DELEGATED DECISION TO DETERMINE APPLICATIONS FOR NON-MATERIAL AMENDMENTS

Reference No: **2024/NM/90761/W**

Site Address: 16, Morton Green, Almondbury, Huddersfield, HD5 8TT

Description: Non material amendment to previous permission 2022/91425 for erection of two storey side extension with front balcony (modified proposal)

Proposed Ground Floor Plan

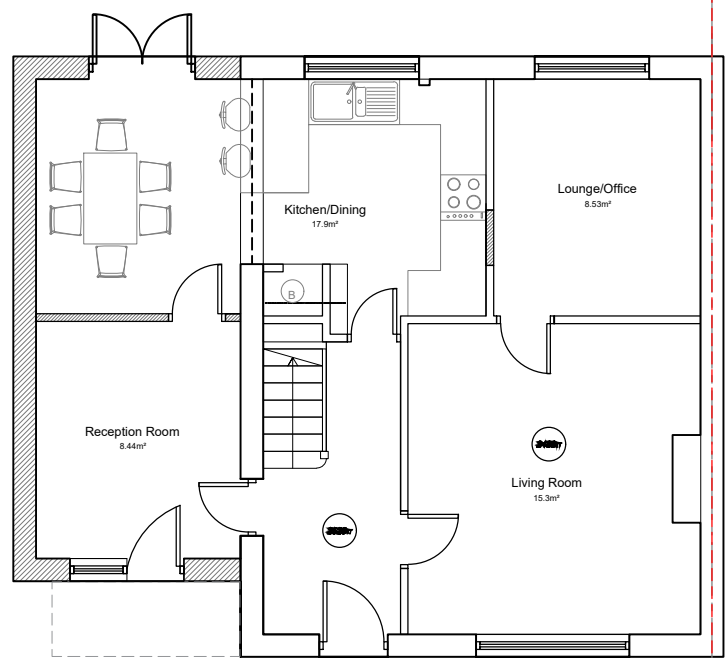
The amendment relates specifically to the two-storey side extension and to its ground floor window to the front elevation previously approved. This window would be altered to a window and door.

The amendment sought is to alter an existing window to be a window and door to the primary elevation of the two-storey side extension as shown on drawing number 190-Arch.24 – Proposed and Existing Floor and Elevation Plans.

Proposed Front Elevation

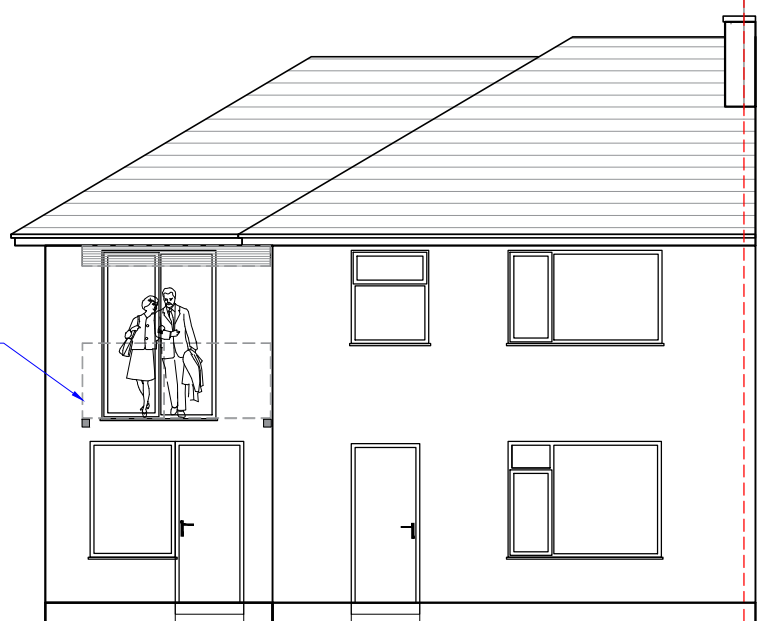
In terms of this particular application, the double window would be reduced in width and would have a solid door. The proposed window and door's considerable separation distance to the opposite neighbour would prevent any additional loss of privacy or amenity to any neighbours. and would not have a change in form of the two-storey side extension. It is also noted that the alteration could be carried out under Permitted Development Rights.
